**RESPONSE TO SUBMISSION (RTS)
Yennora Liquid Waste Treatment Plant
14-16 Kiora Crescent, Yennora (SSD 10407)**

Report No: 191251_RTS_Rev2
February 2021
(Released: 16 February 2021)

Figure 6: Swept paths for heavy vehicles accessing the site at 14-16 Kiara Crescent, Yennora

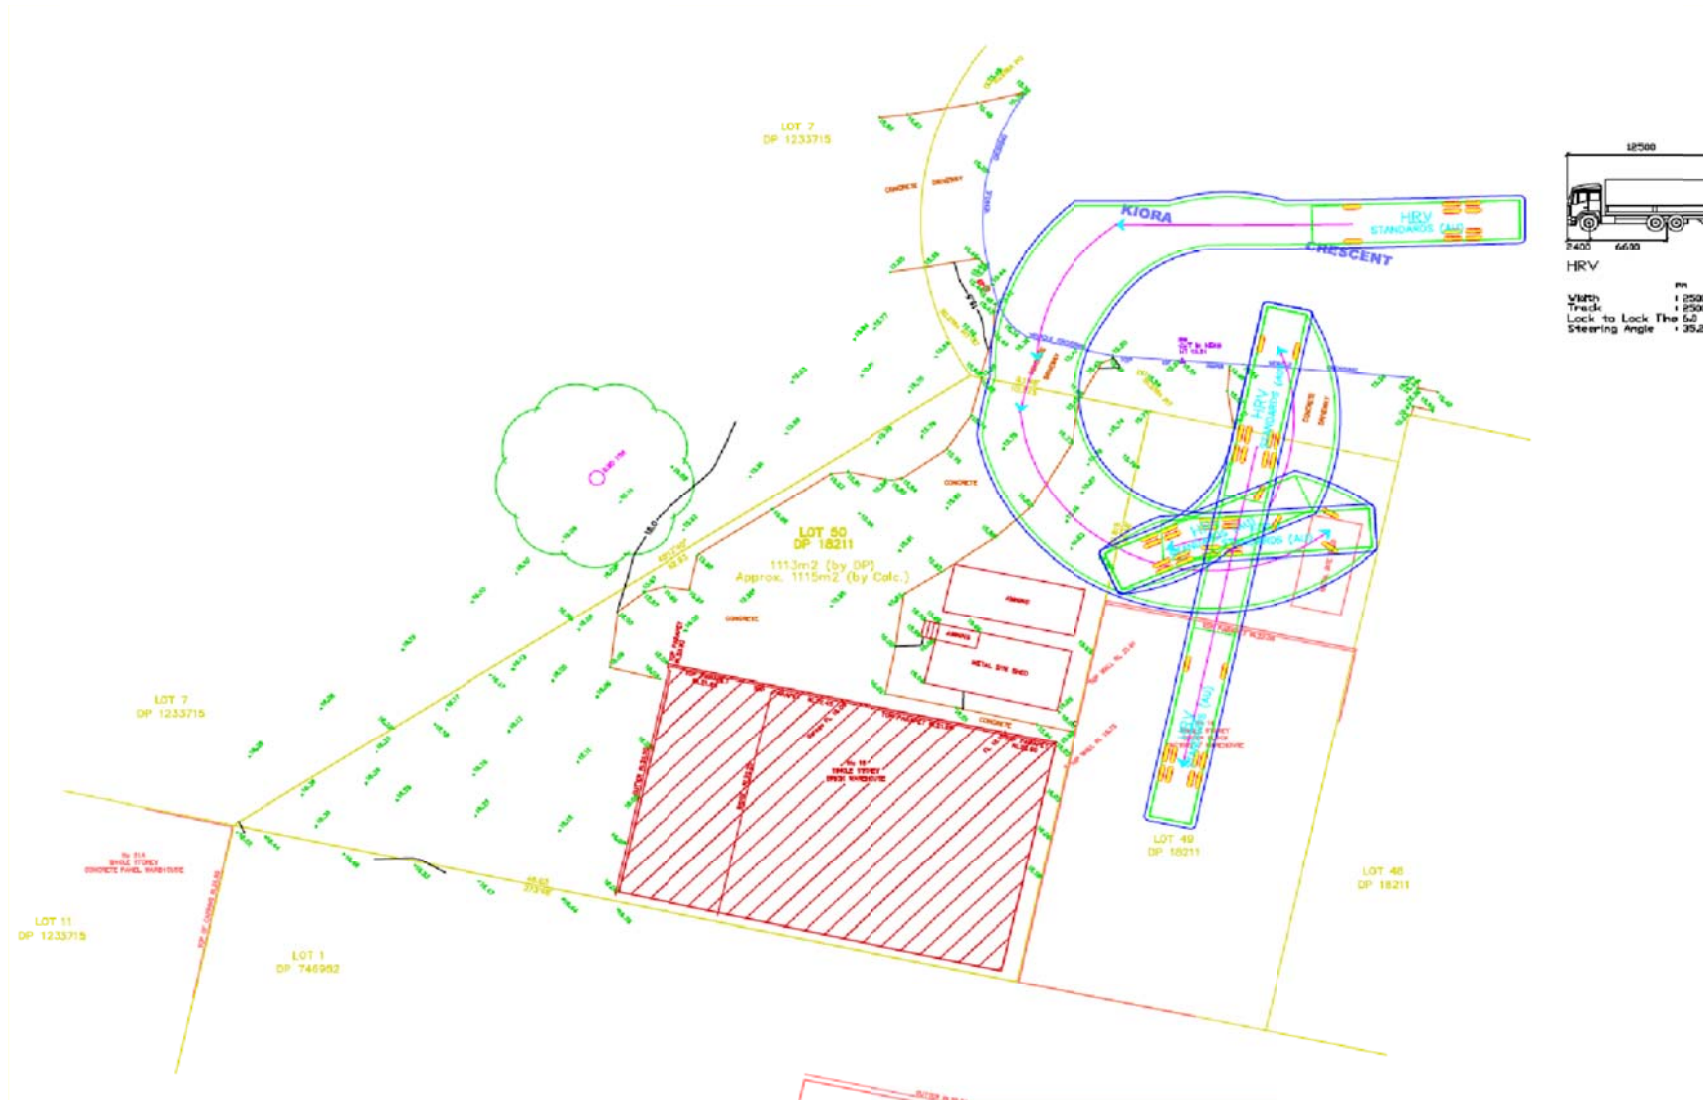
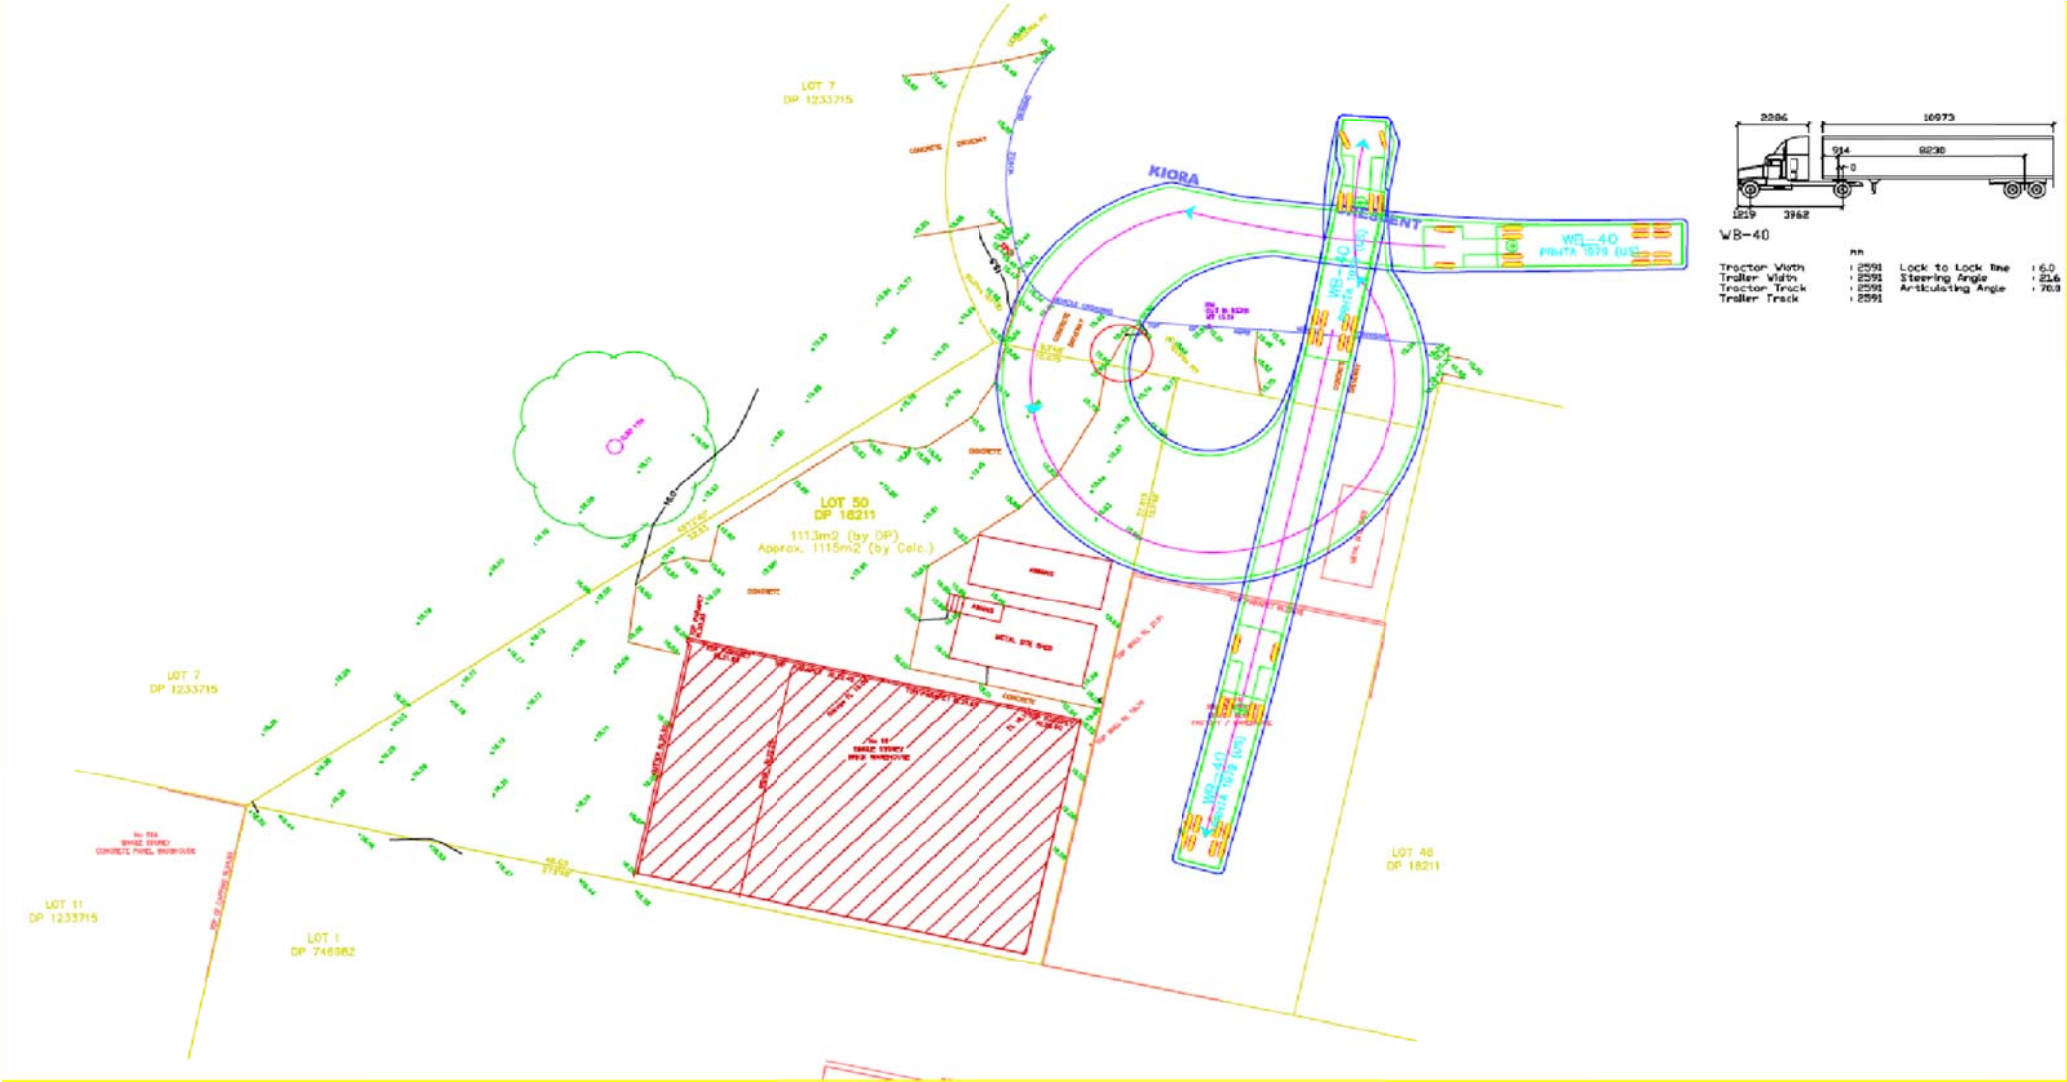
- *Previous advice provided by the Department and Council to the Applicant has outlined that the internal swept path movements are not appropriate and need to be updated to demonstrate that turning paths would not encroach onto Council footpath, nature strip or any other infrastructure located on Council land. It is noted that the advice has not been considered in the EIS, it is required that mitigation measures and/or alternatives need to be considered and subsequently updated to meet Council and the Department's requirements.*

- *The manoeuvring and turning of the vehicle must be completed within the site and must not cause encroachment into nature strip or the footpath. The swept path diagrams demonstrate otherwise with the encroachment into nature strip. As per previous correspondence the Department requested the proponent consult with Council to resolve internal swept path movements satisfactorily. Please provide further evidence of any further consultation with Council regarding the outcome and resolution of these issues.*

There is no footpath at the front of the site. Turning paths encroach on the nature strip and have resulted in proposed driveway widening. A letter to council was sent on the 6th of the October 2020 seeking advice on this matter (Ref:191251_Let5_Rev2 provided in attachment 10). Advice from council was received via email on 15th October 2020 provided in attachment 10. The advice

presented by Council has been considered, resulting in several site changes. Following receipt of this advice (which was the same as stated in the original comments within the SEARs), Benbow Environmental phoned Senior Development Engineer, Bala Sudarson for advice to discuss potential viable solutions that may satisfy Council comments. However after seeking feedback from the traffic team, Council responded by advising that they could not provide any alternative solutions to those proposed, nor were they capable of supporting the on-site traffic manoeuvring presented in the proposed development.

The above changes has allowed for improved on site manoeuvring of vehicles and three (3) of the five (5) original Council requirements to be met. Trucks can enter and leave the site in a forward direction without encroaching on the nature strip. There is space for 7 on site car parking spaces and truck swept paths do not interfere with car parking spaces.

Figure 1: Site Plan

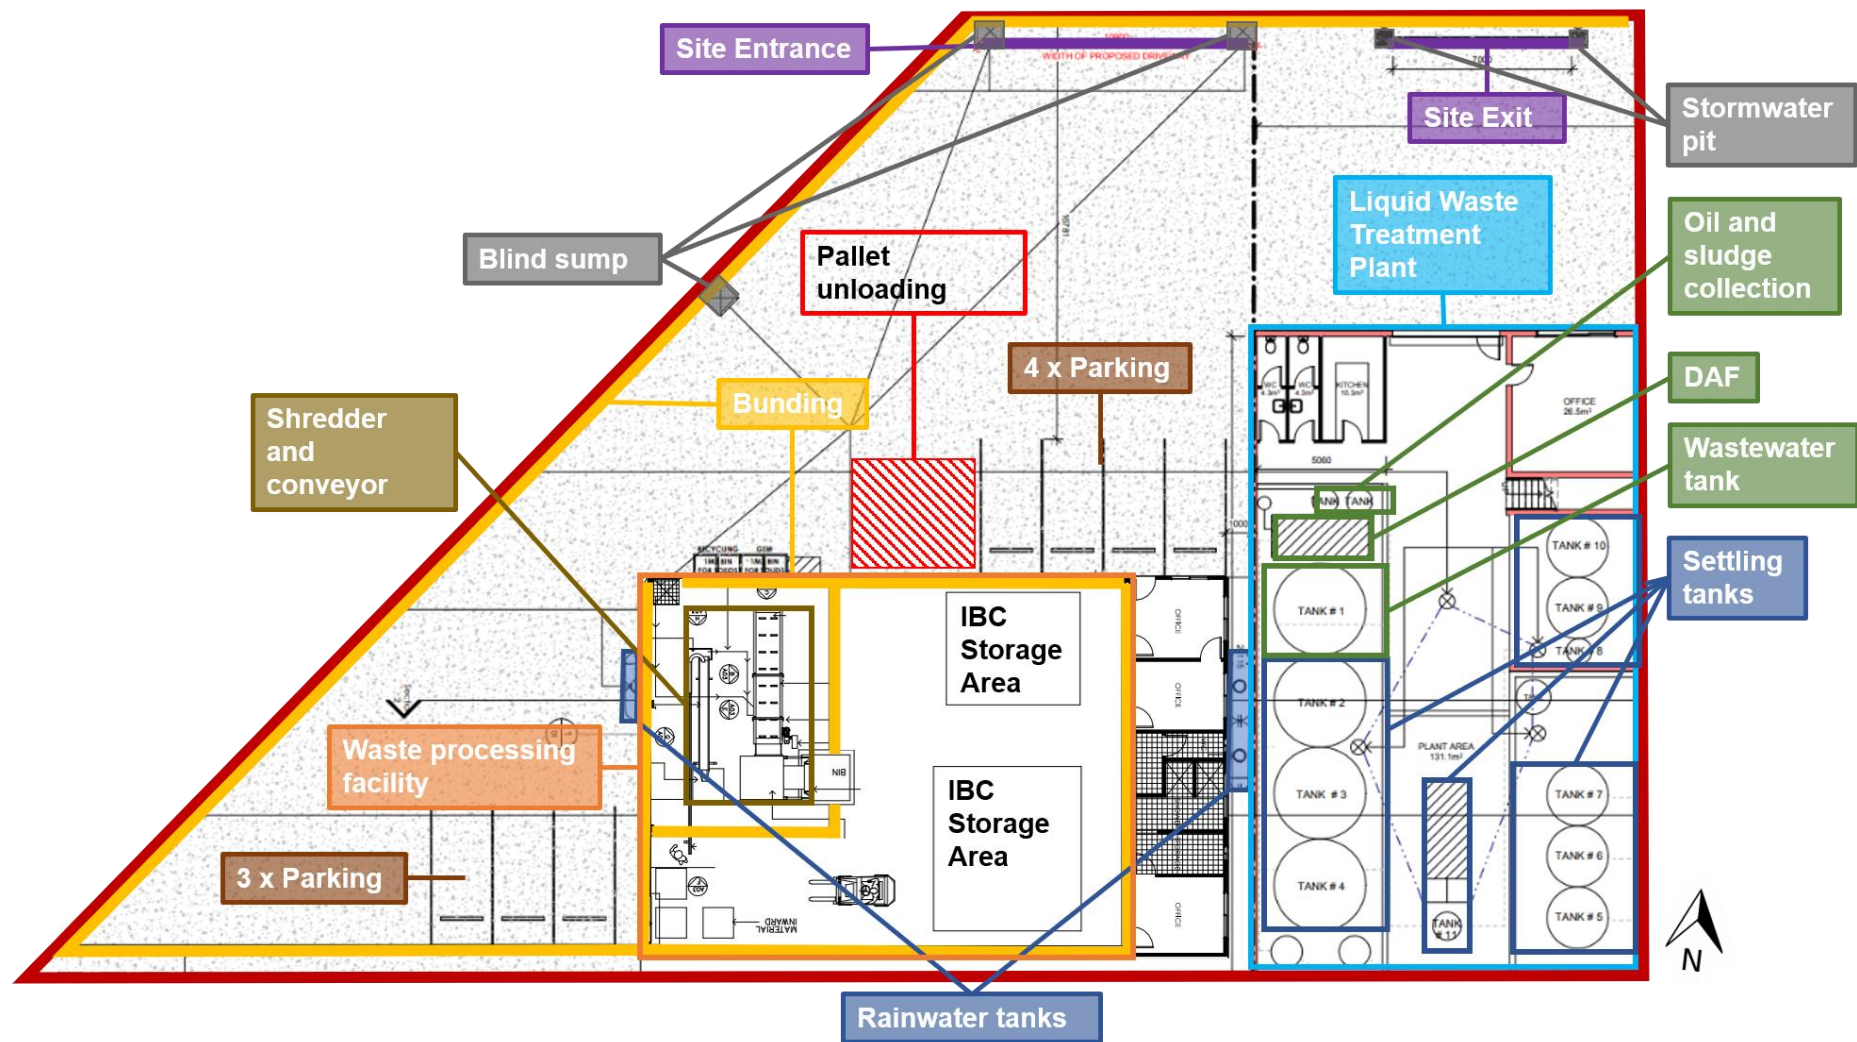
- The site plan provided in Appendix 1 indicates that works would be carried out to widen the site entrance at 16 Kiora Crescent. Please provide further description of these works. The width of the proposed driveway shown in the site plan extends over two existing stormwater pits. Please advise if these stormwater pits would be required to be relocated or managed to allow the widening of the site entrance. The proposed driveway widening works should also form part of the proposed development description and the be reflected in the QS report.*

- Update site plans to show the dimension of the site access upgrades proposed for the driveway entrance at 16 Kiara Crescent.
